Land North West of Bicester

Third Environmental Statement Addendum

Prepared on behalf of Firethorn Developments Ltd

March 2022

APPENDIX 4
DEVELOPMENT PARAMETER PLAN 3 – ACCESS AND MOVEMENT
(Amended)

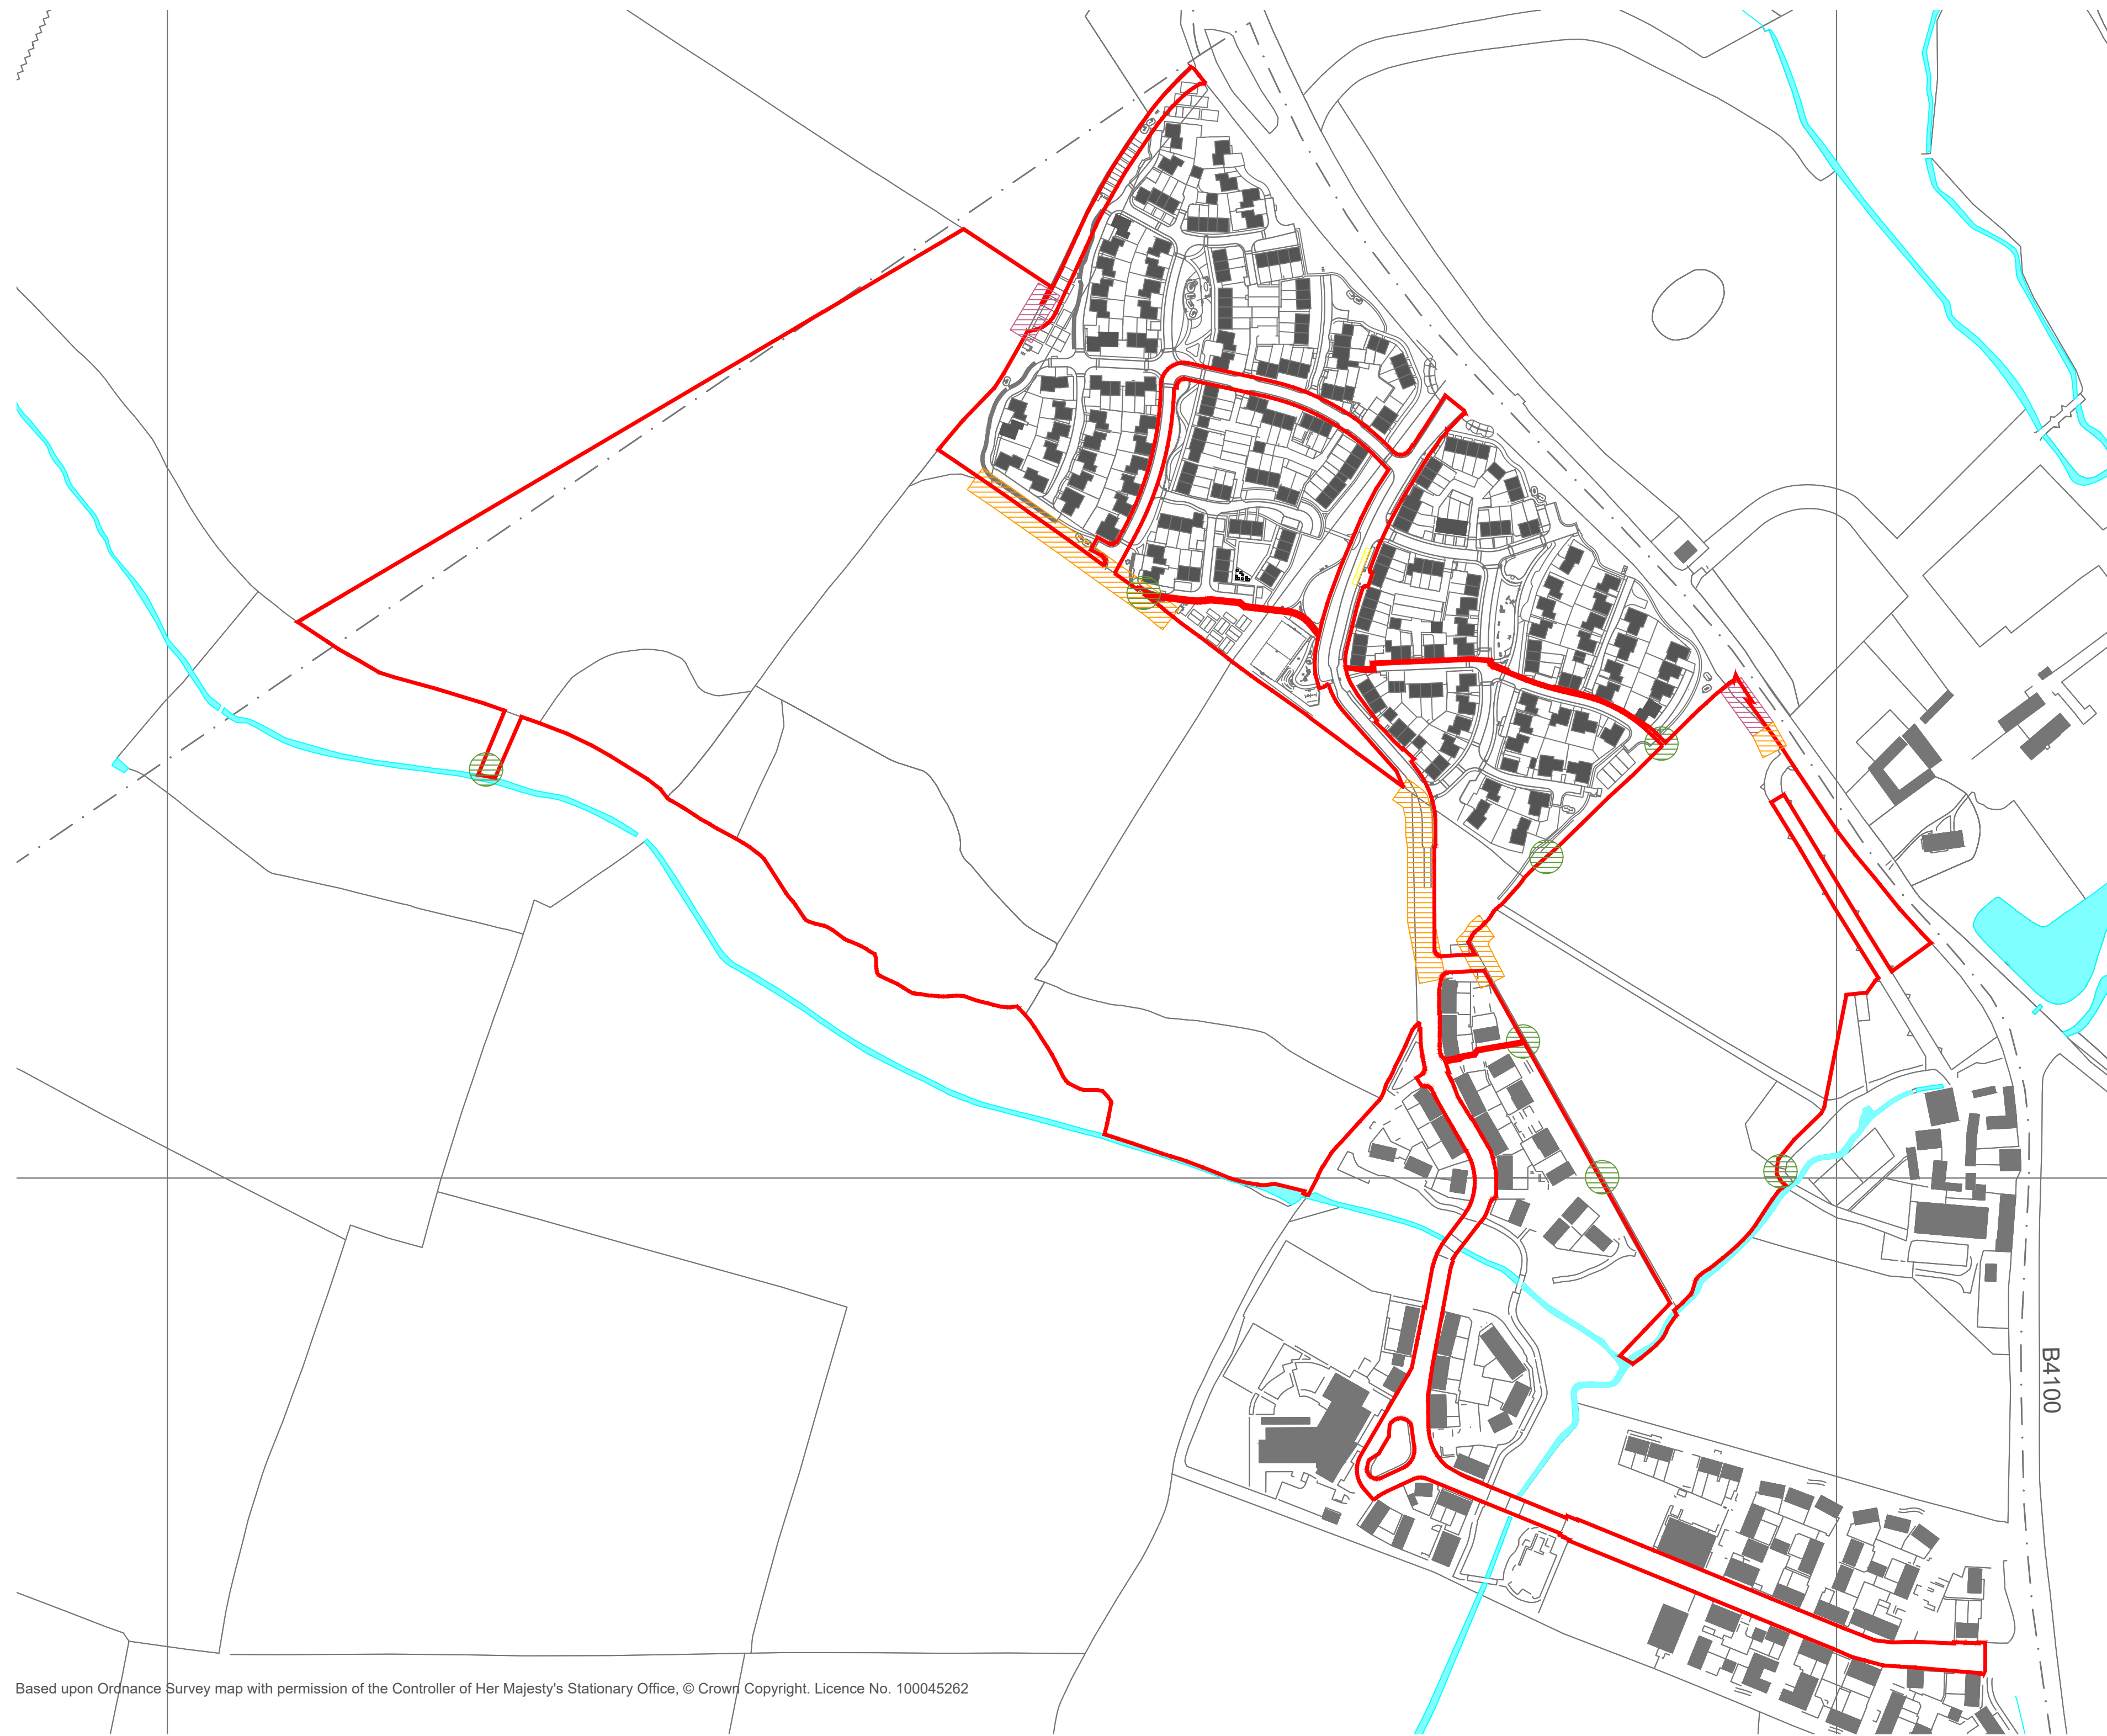
- A.13 Consultation comments received from Oxfordshire County Council Highways identified that the Access and Movement Parameter Plan (Figure 3.3 in the May 2021 ES and Figure 3.3A in the second ES Addendum in November 2021) should be amended to include not just the confirmed pedestrian and cycle access points but all possible pedestrian and cycle access points. The parameter plan has therefore been amended and is provided in this third ES Addendum as Figure 3.3B Access and Movement Parameter Plan. The ES has been reviewed to identify any significant effects that would result from this change, and it has been concluded that subject to ensuring the mitigation measures as set out in the May 2021 ES (such as ensuring that where possible access points should utilise existing gaps in the hedgerows to minimise landscape or biodiversity effects) are complied with, no new or amended significant effects would result and therefore no further amendments are required.

- **Update of the parameter plan Figure 3.3 to reflect the revised potential pedestrian cycle access provision.**

highway connection points, as shown on Figure 3.3~~A~~**B**. Pedestrian and cycle connections will be provided at each of the vehicular access points. Safe and attractive environments for walking and cycling will be provided to encourage local journeys to be made sustainably.
